COMMUNITY SERVICES DEPARTMENT

Subject: Romens Final Plat (SF2226)

The Community Services Department has reviewed the Romens Final Plat application and is providing the following preliminary comments on behalf of El Paso County Parks. This application will be presented to the Park Advisory Board on September 14th and its recommendation will be provided after the meeting.

FINAL PLAT

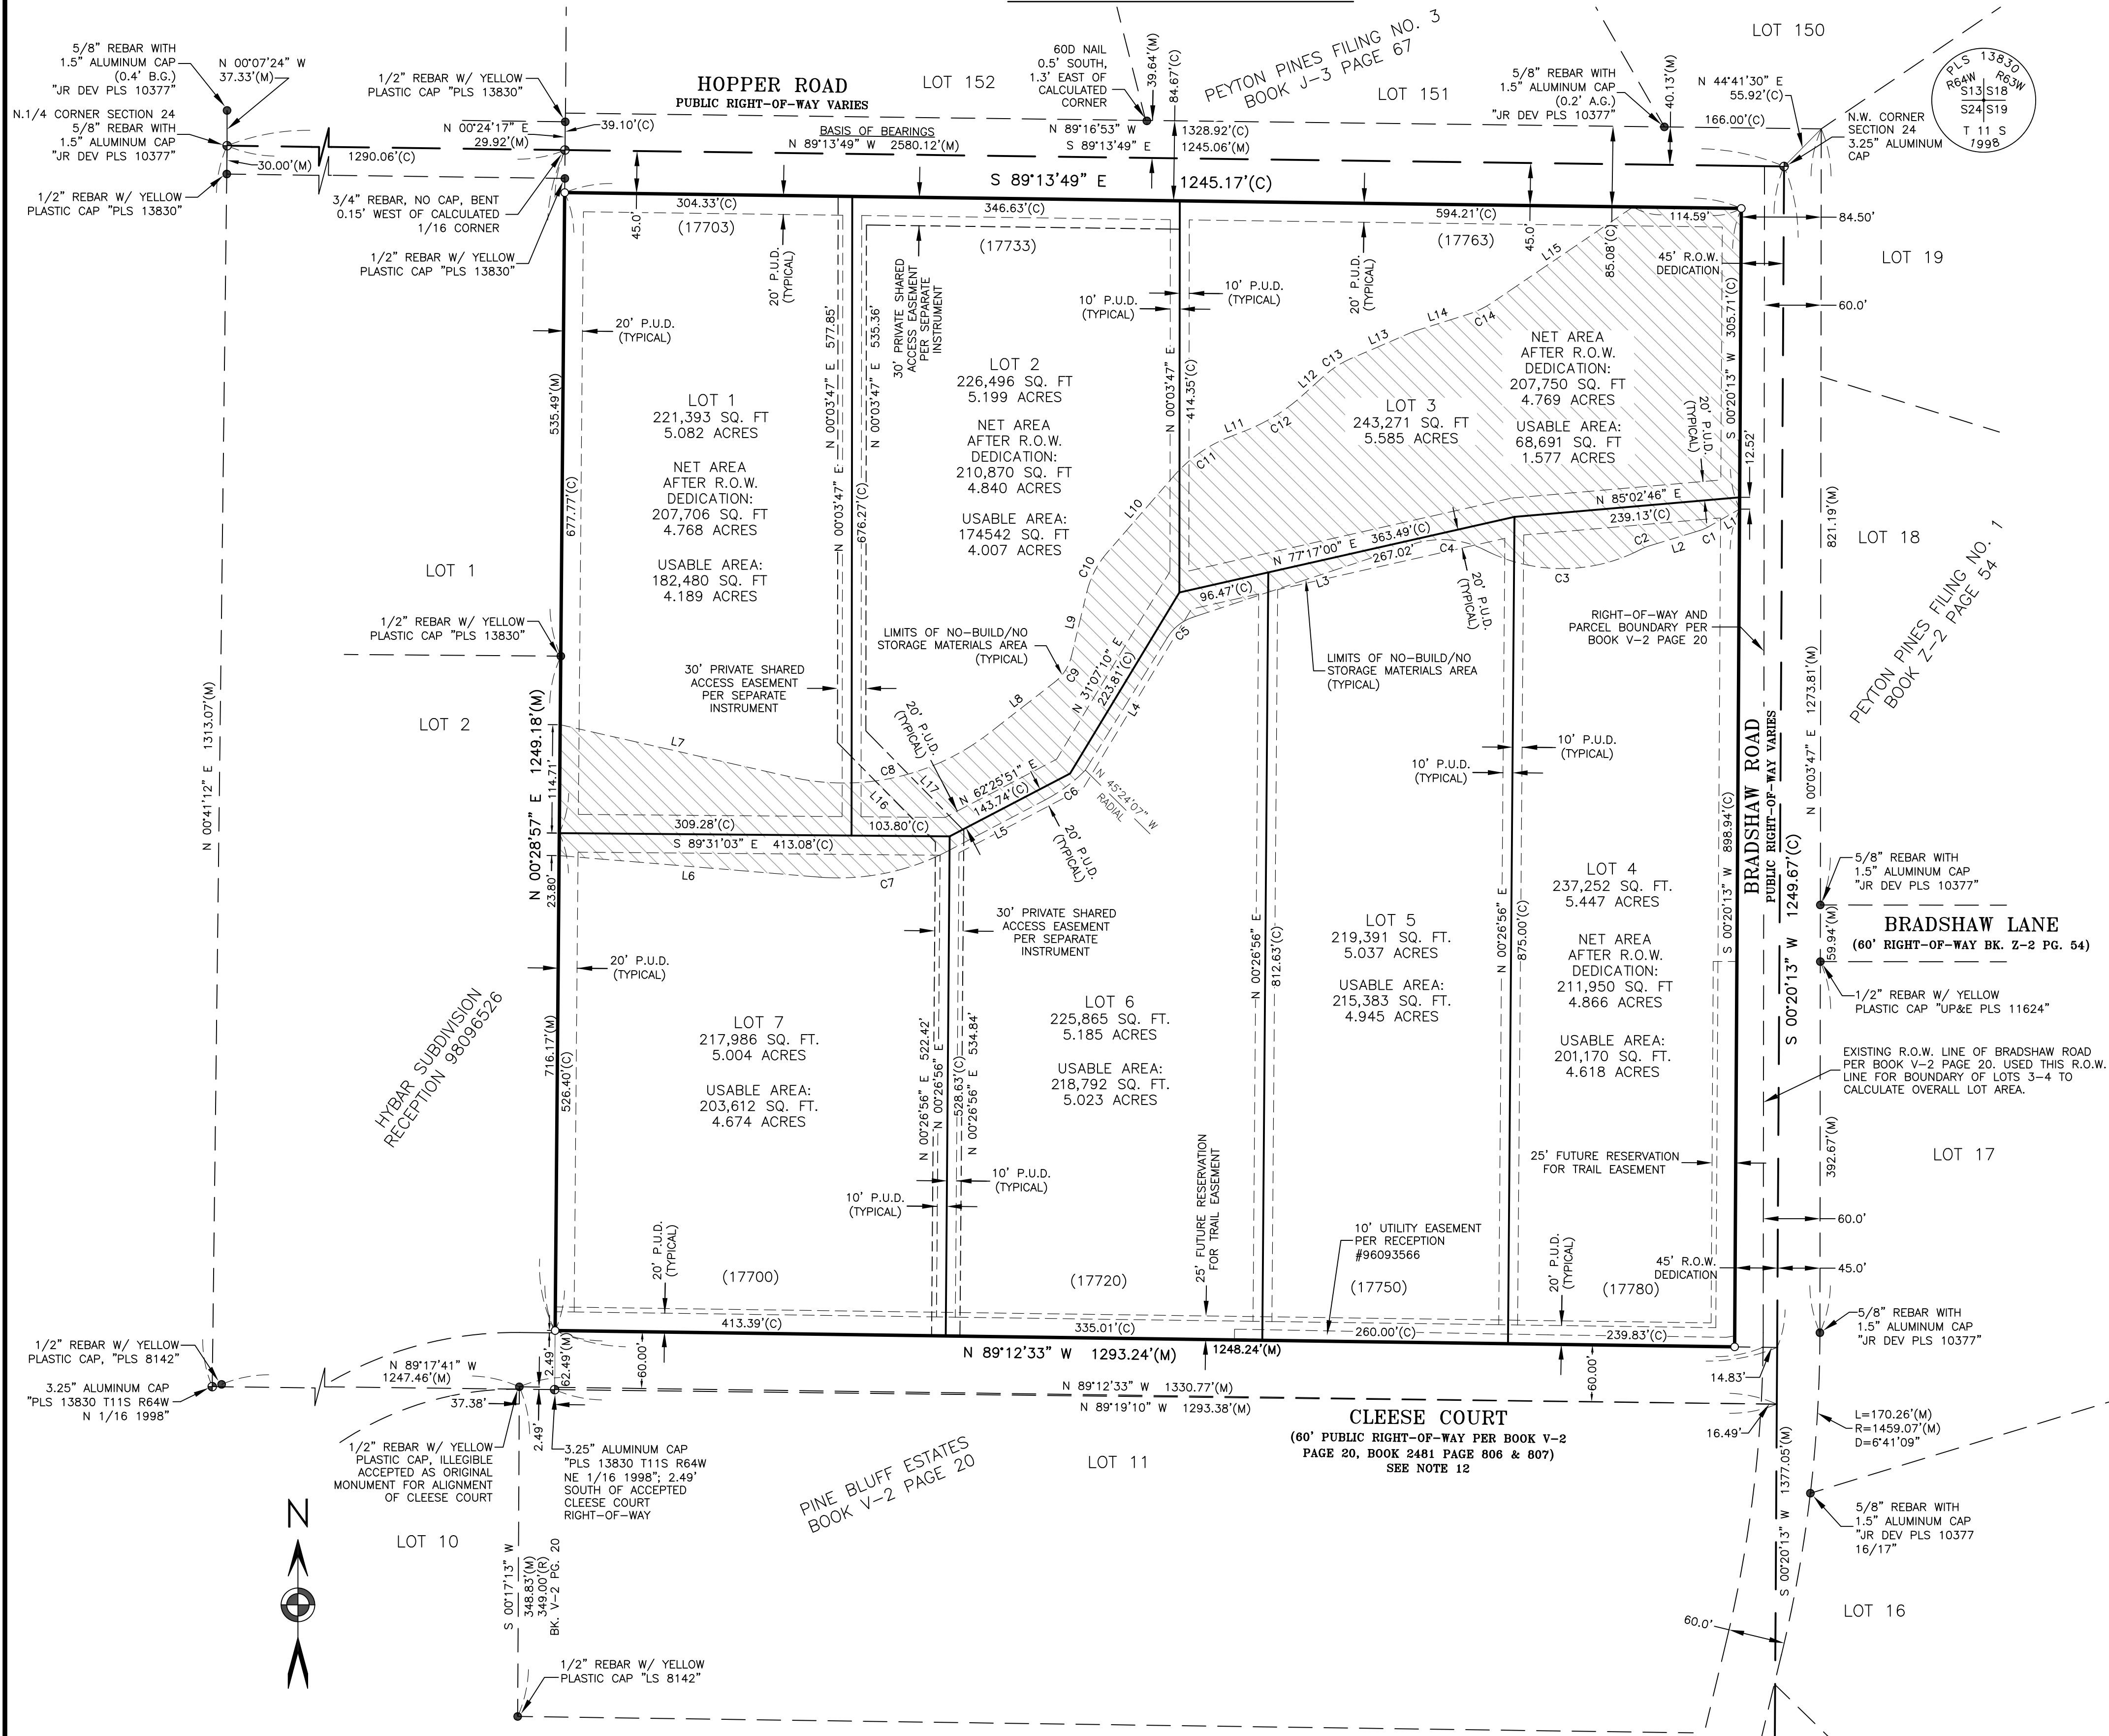
County Parks requests trail easements where development projects impact proposed County trails. As it pertains to this application, the County requests that the landowner provide a 25-foot-wide public trail easement along the south side of the development, outside the drainage and utility easement, and from the SE corner of the development north to the intersection of Bradshaw Lane that allows for the construction and maintenance by El Paso County of the Palmer Divide Regional Trail.

The Park Advisory Board recommends that the Planning Commission and the Board of County Commissioners include the following conditions when considering and/or approving the Romens Final Plat: (1) designate and provide to El Paso County a 25-foot-wide public trail easement along the south side of the development, outside the drainage and utility easement, and from the SE corner of the development north to the intersection of Bradshaw Lane that allows for the construction and maintenance by El Paso County of the Palmer Divide Regional Trail, and dedicate the easement to El Paso County prior to the recording of the Final Plat (2) fees in lieu of land dedication for regional park purposes in the amount of \$3,220 will be required at the time of the recording of the forthcoming Final Plat.
